GEORGE F. WHITE

Extension: 3207
Mobile: [REDACTED]
Email: [REDACTED]
Our Ref: Job-0000462/DRP/CH/LAA
Your Ref:
Date: 16 November 2022

A66 NORTHERN TRANS-PENNINE PROJECT MAINSGILL FARM – MR & MRS HENSHAW

Drawing Title
Rights of Way & Access Plans
Regulation 5(2)(k) & 5(2)(o)
Sheet 1 of 1

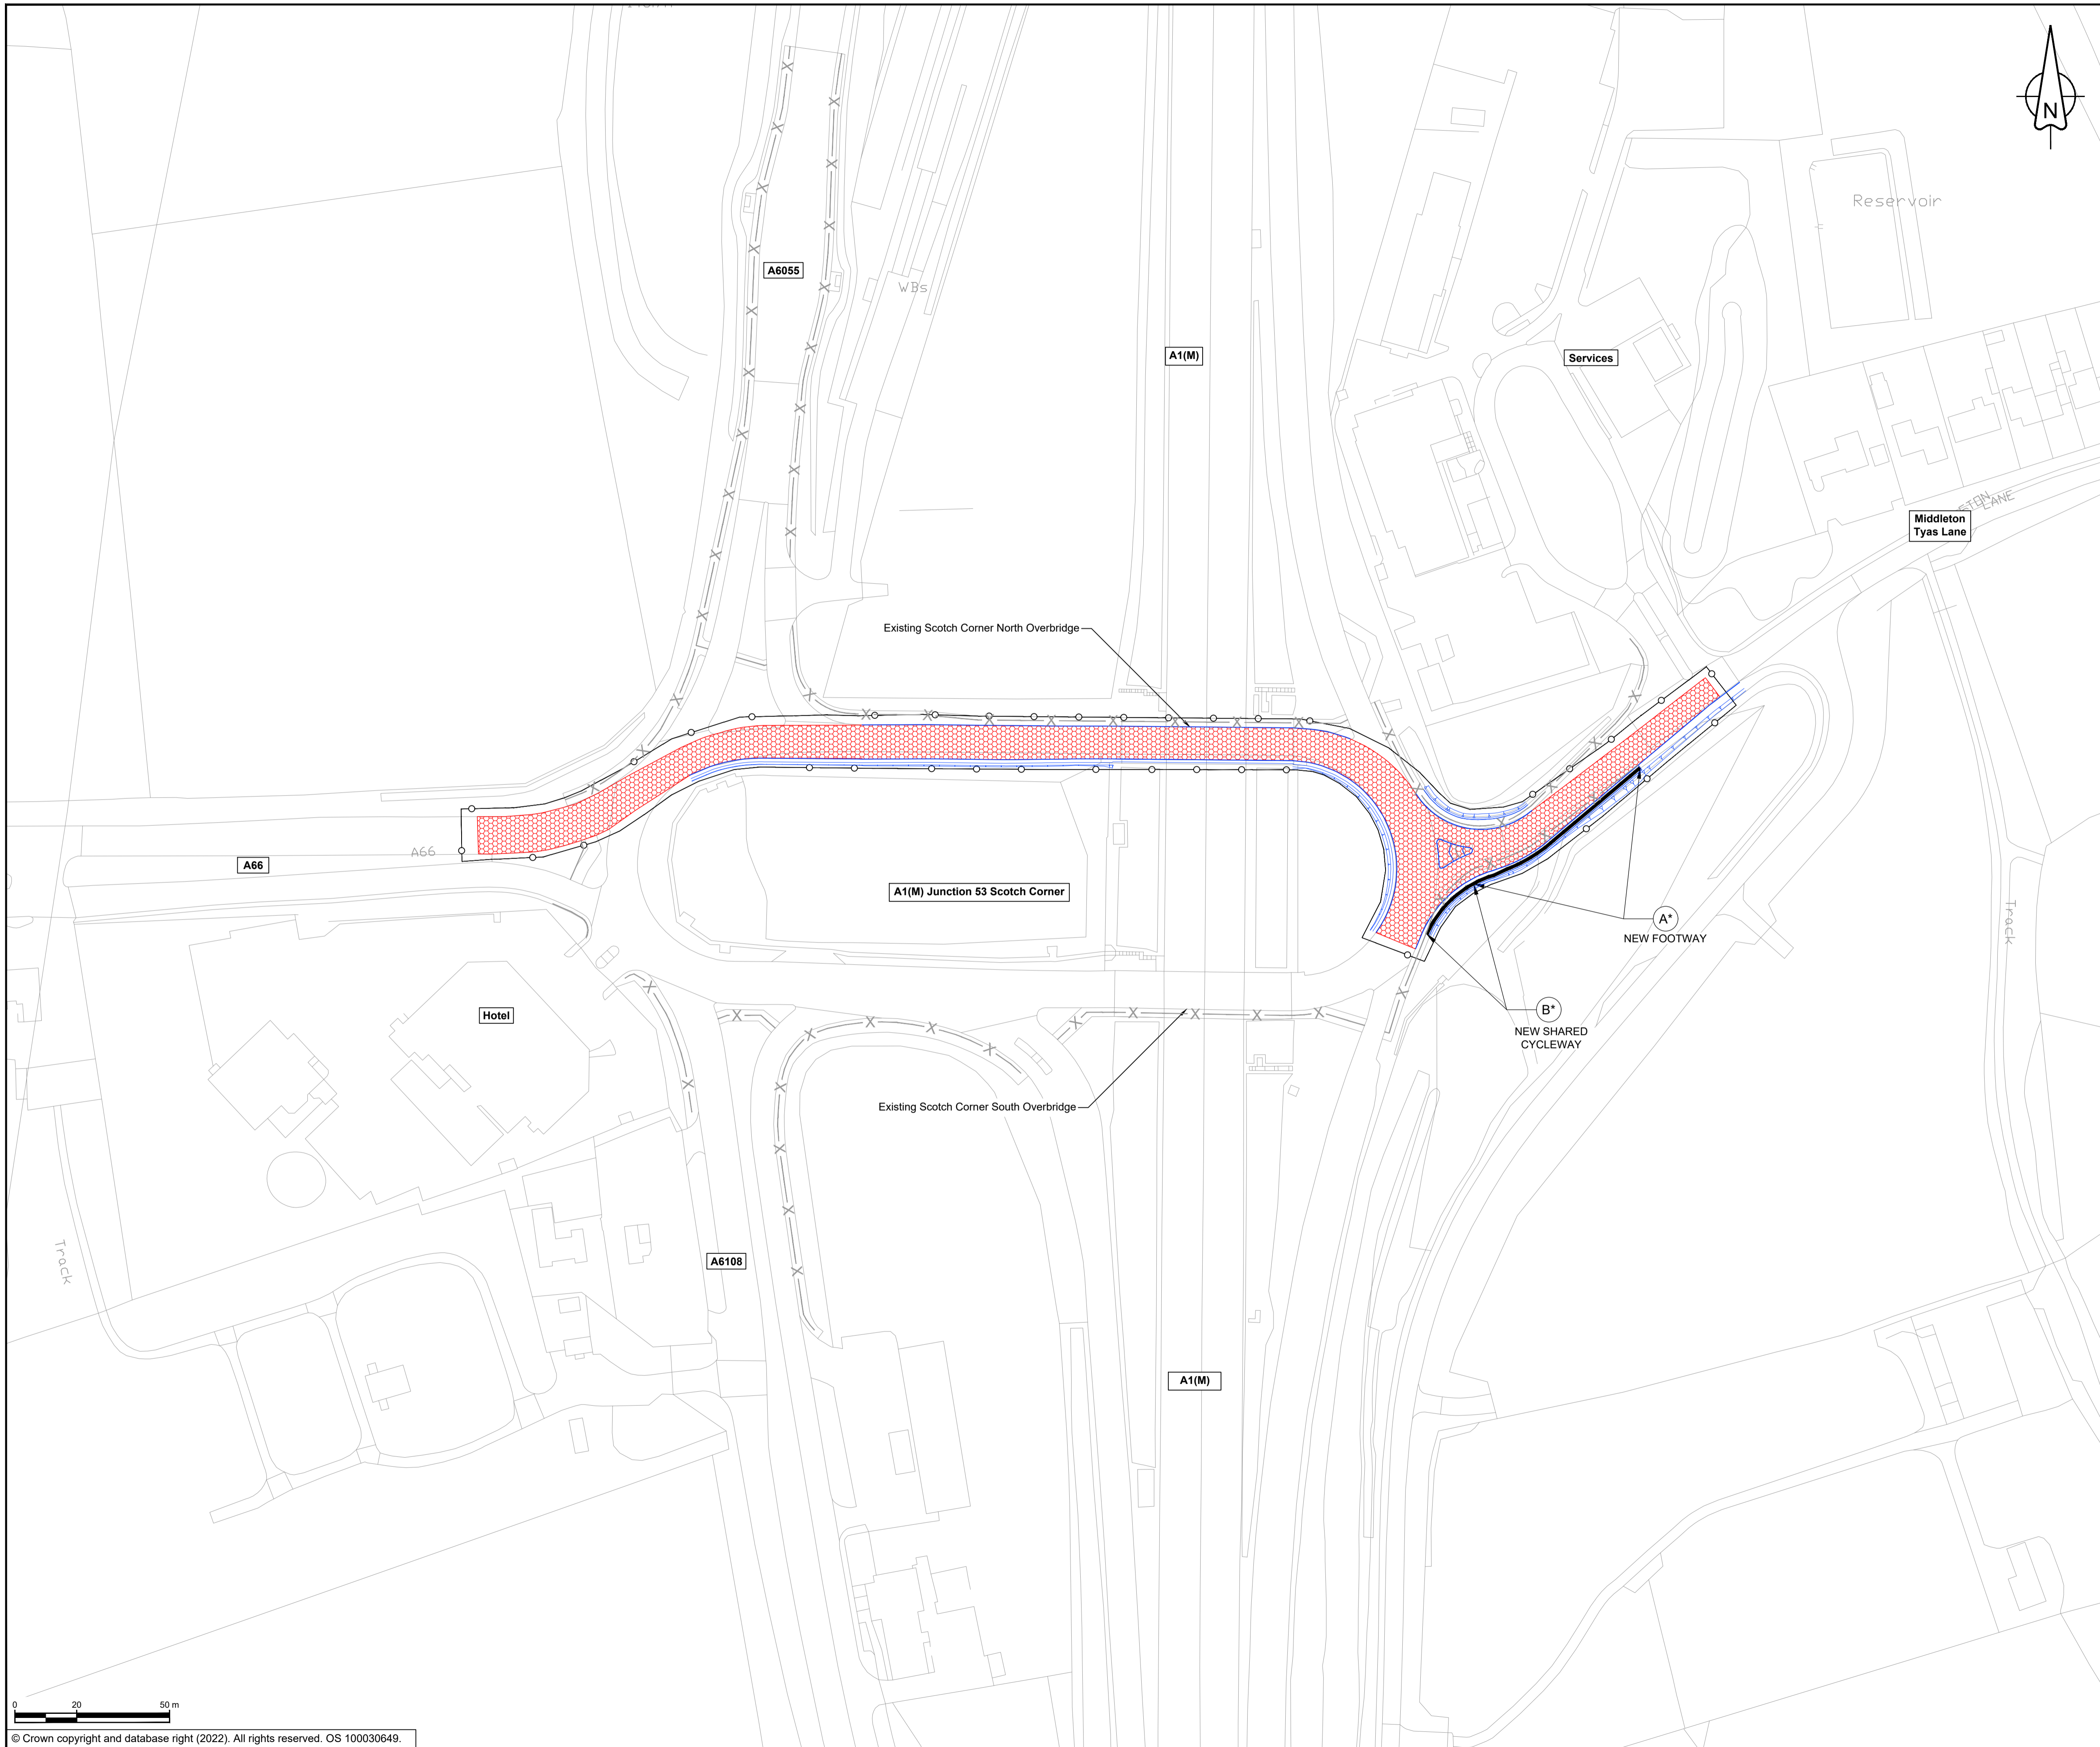
As you will be aware the initial design meant there was a service road from Warrener Lane to Brownson Bank. This was purely a service road only and access could not be taken directly onto the A66 at Brownson Bank. My clients discussed this with Highways and my clients understood that this was the design that was being pursued.

Since then, Highways have changed the design without consulting my client, meaning that the once proposed service road is now in fact a through road and all vehicles can take access onto the A66 at Brownson Bank. This changes the situation that my client and their business will be in.

As you know there is traffic constantly going in and out of Mainsgill and there are future plans at Mainsgill to ensure their business continues to operate at a level which it is at present, which it will not be able to do since Highways have since changed the design without consulting my client, therefore we request that an access is installed further East to ensure there is a customer access point and a delivery access point.
